From: Michael Eastham
Sent: 23 August 2017 12:09
To: 'Matthew Driver'
Subject: FW: BN/28/17/RES - The Lillies, Barnham Road

From: Paul Cann
Sent: 23 August 2017 11:52
To: Michael Eastham
Subject: RE: BN/28/17/RES - The Lillies, Barnham Road

SCALE	DATE	AUTHOR	CHK'D
1:1250 @ A3	April 17	FK	
JOB NO.	DRAWING NO.	REV	
MATT151202	LP.01	A

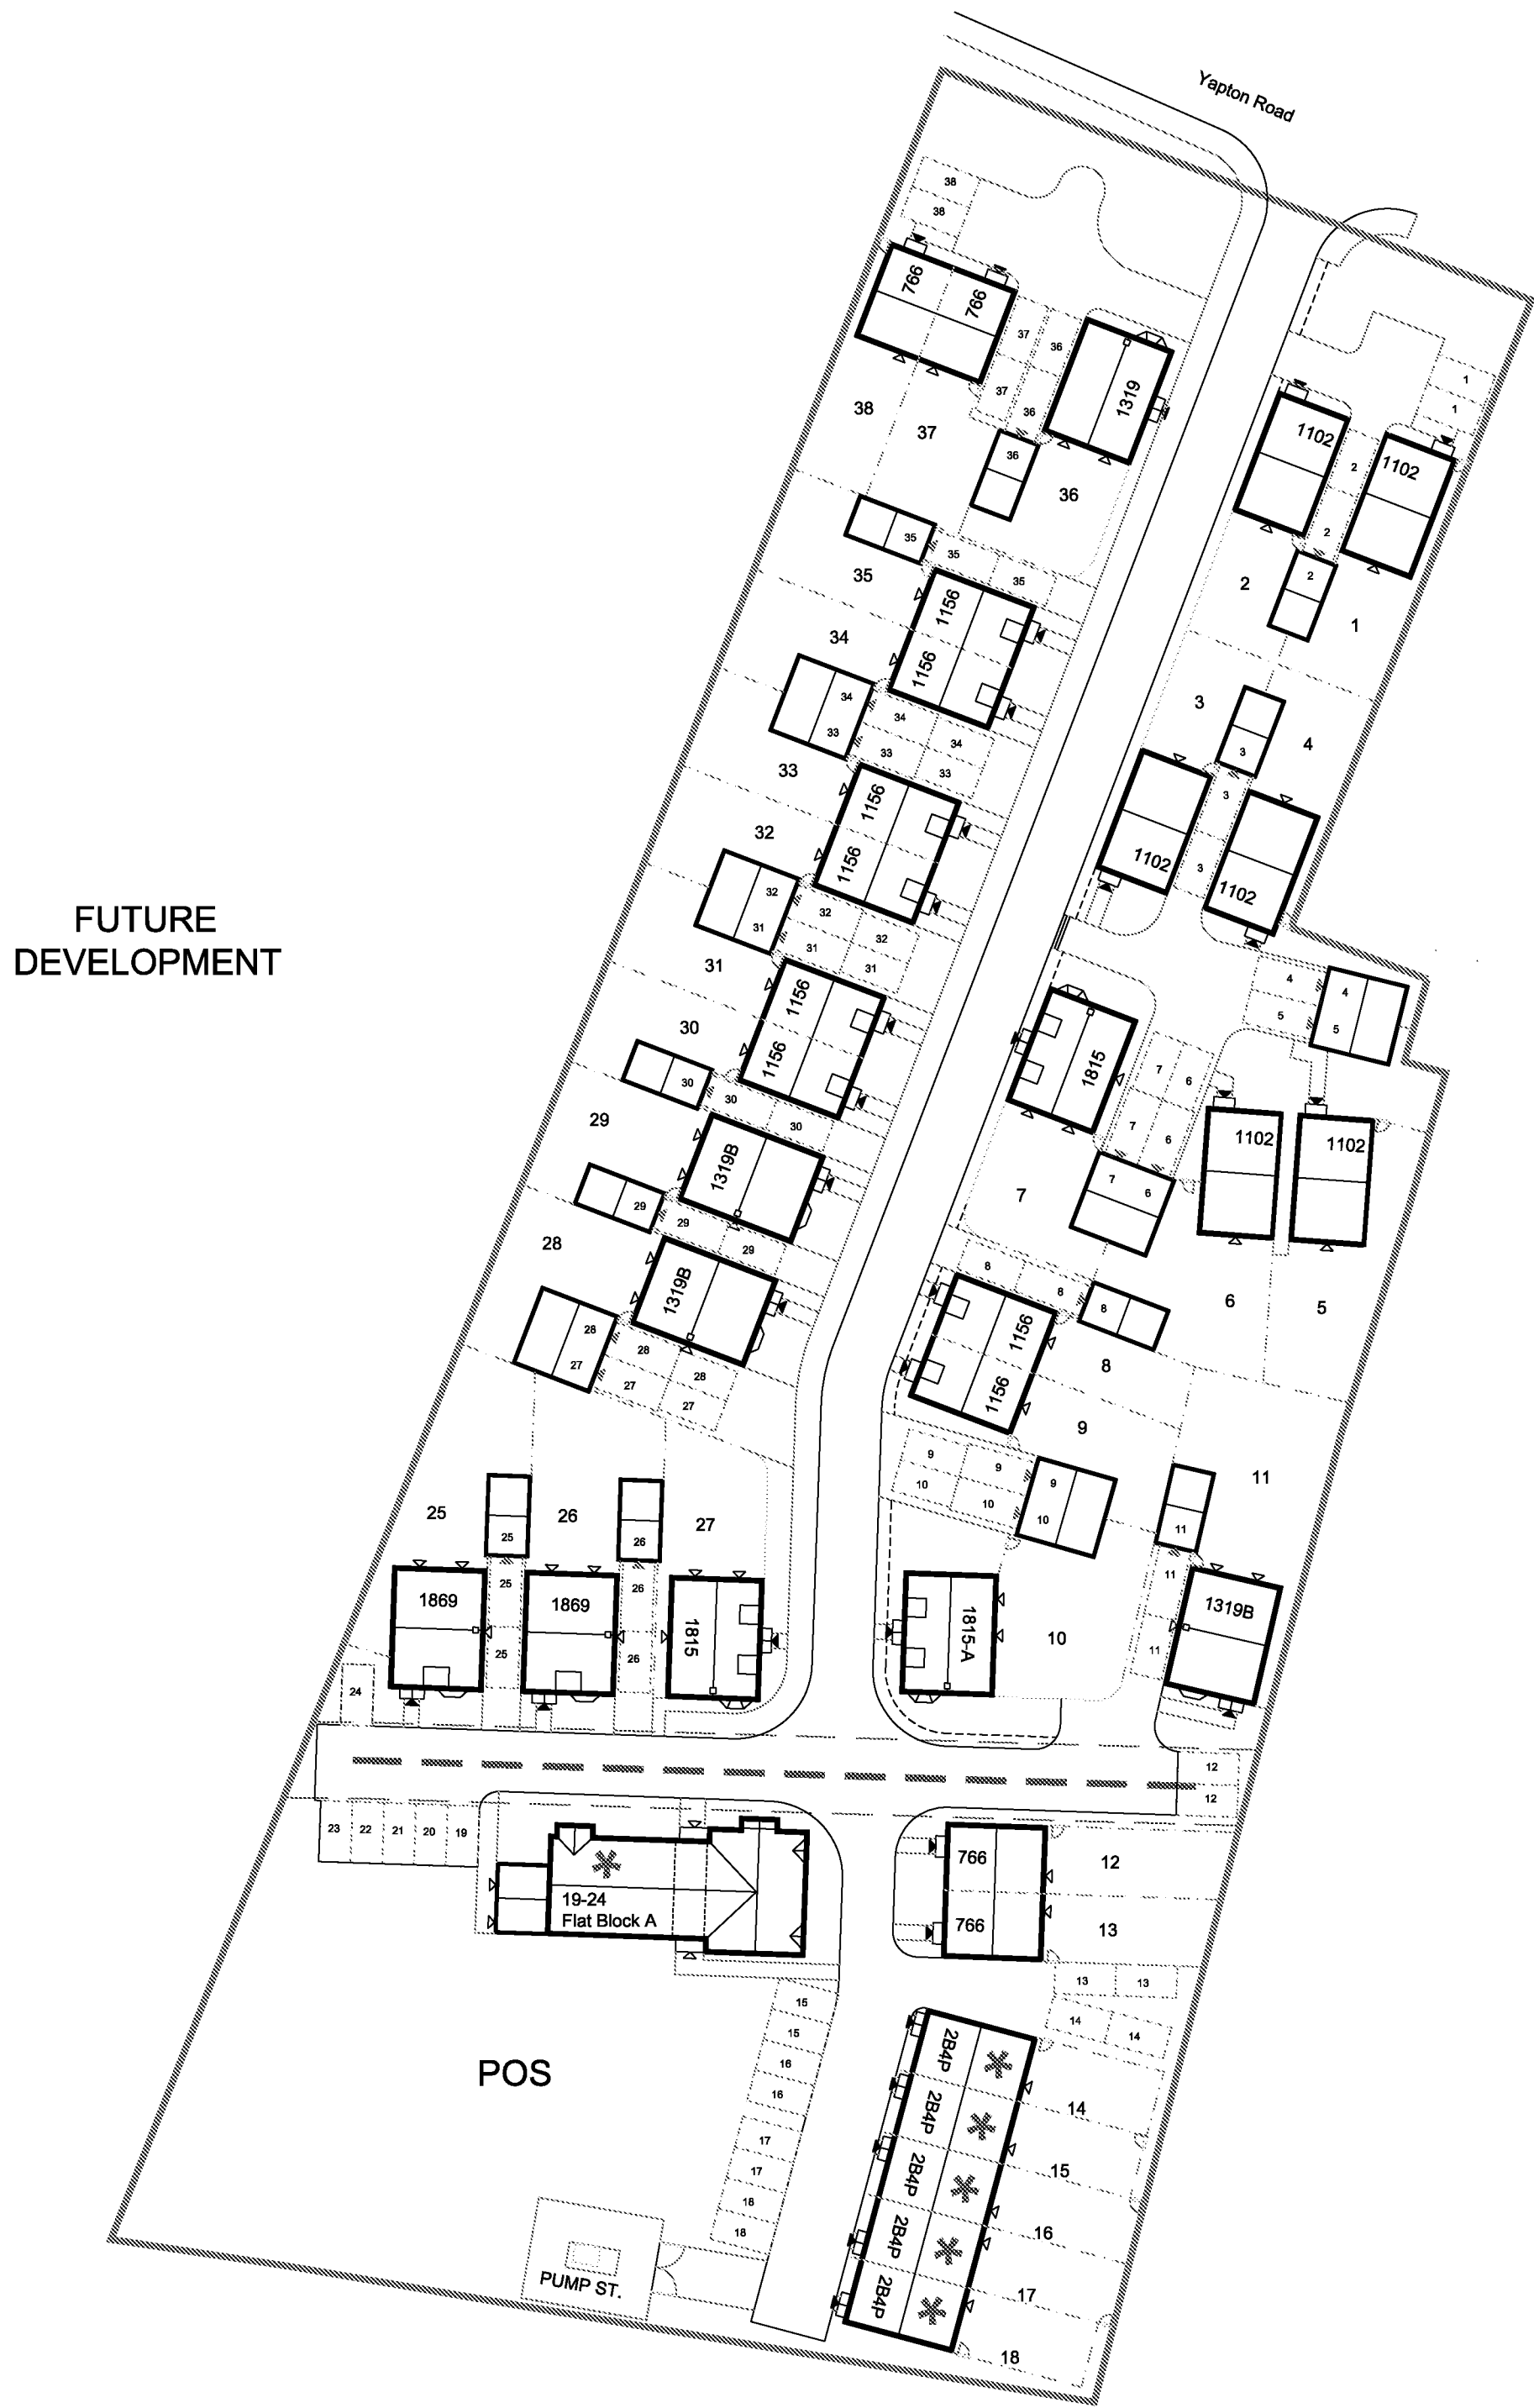
A three metre wide easement strip is required from the top of the bank and to be free of all obstructions including boundary fences. The foul water pumping station compound and one of the dwellings conflicts with this requirement. – From what I can see in the conditions there is no specified distance re 3m off-set.

This is the reason for condition no.9 ie. they need to agree access . The 3m distance is a standard width needed for maintenance purposes. If they had discussed it with us, then we would have told them our requirements.

JOB NO.	DRAWING NO.	REV
MATT151202	SL.01	P5

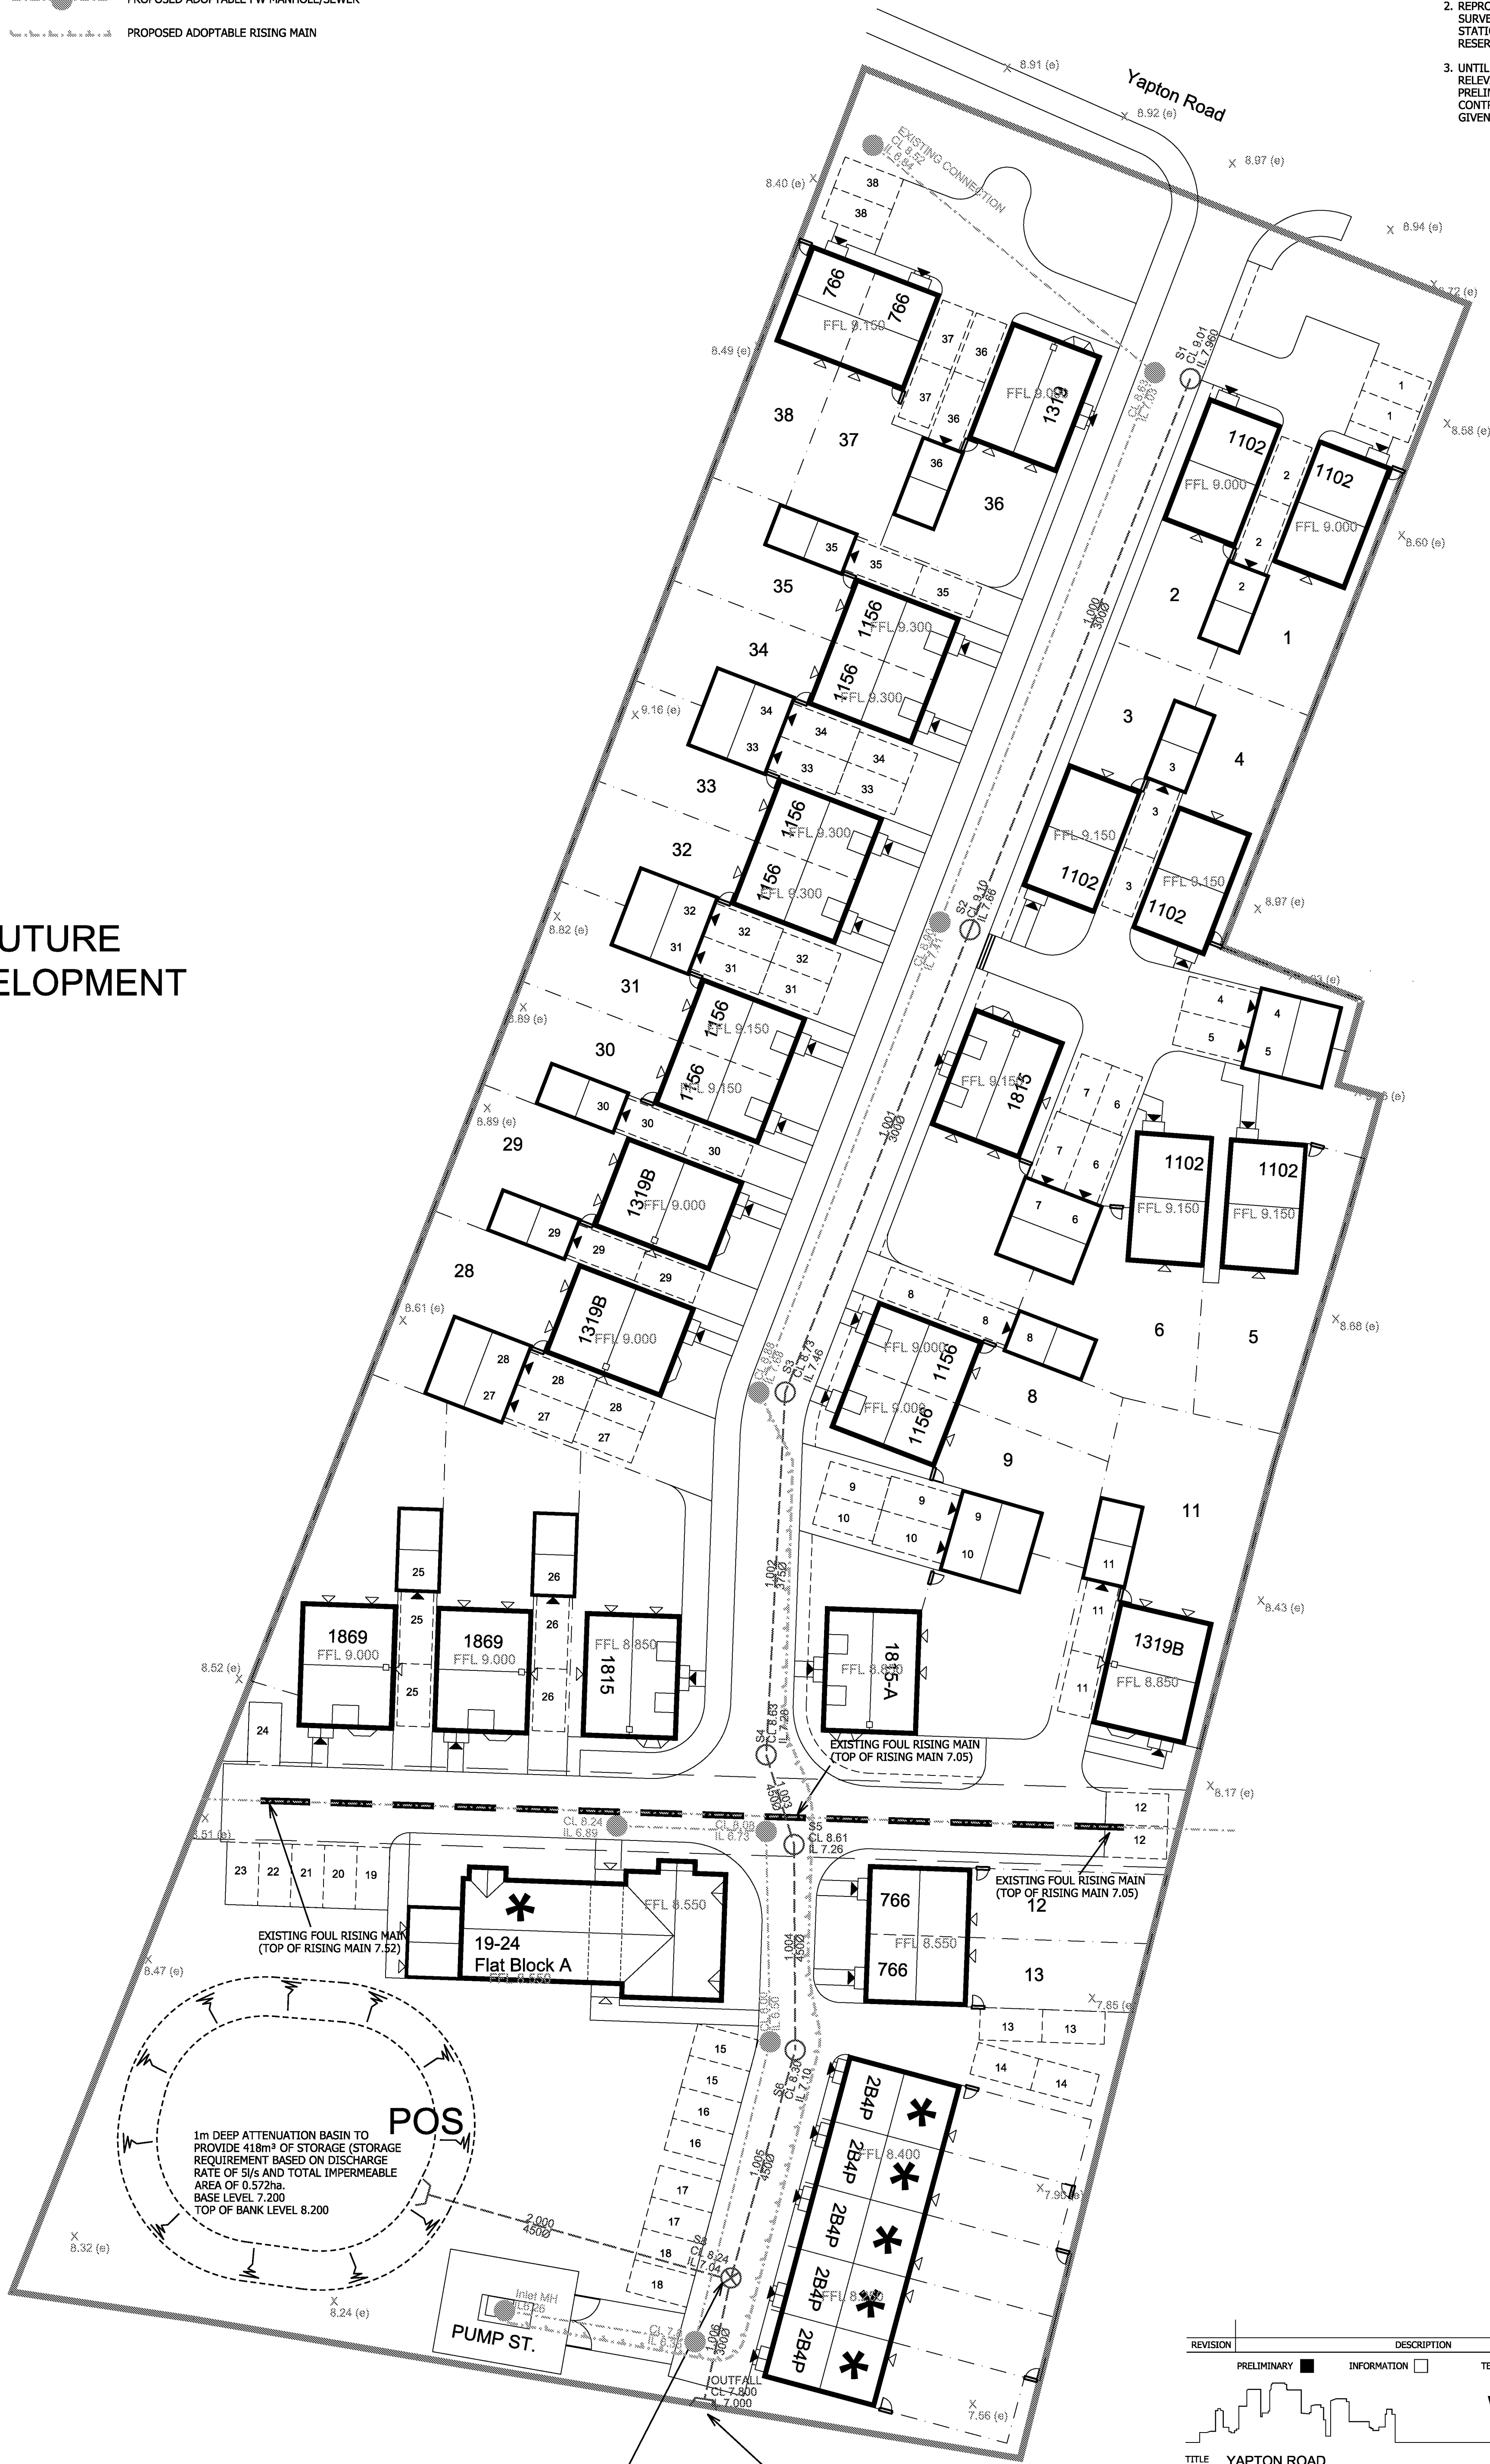
The principle of the surface water drainage scheme is acceptable, however, its detailed design will need to be agreed. This will include hydraulic calculations to confirm the sizing of the pond, construction details of the pond (taking into account potentially high groundwater levels/floatation), full details of the remainder of the surface

Yes hydraulic calculations are included, however, we need a full package of information (ie. that stated above) before we can consider them. The calculations may also change if permeable paving is introduced as per item below.
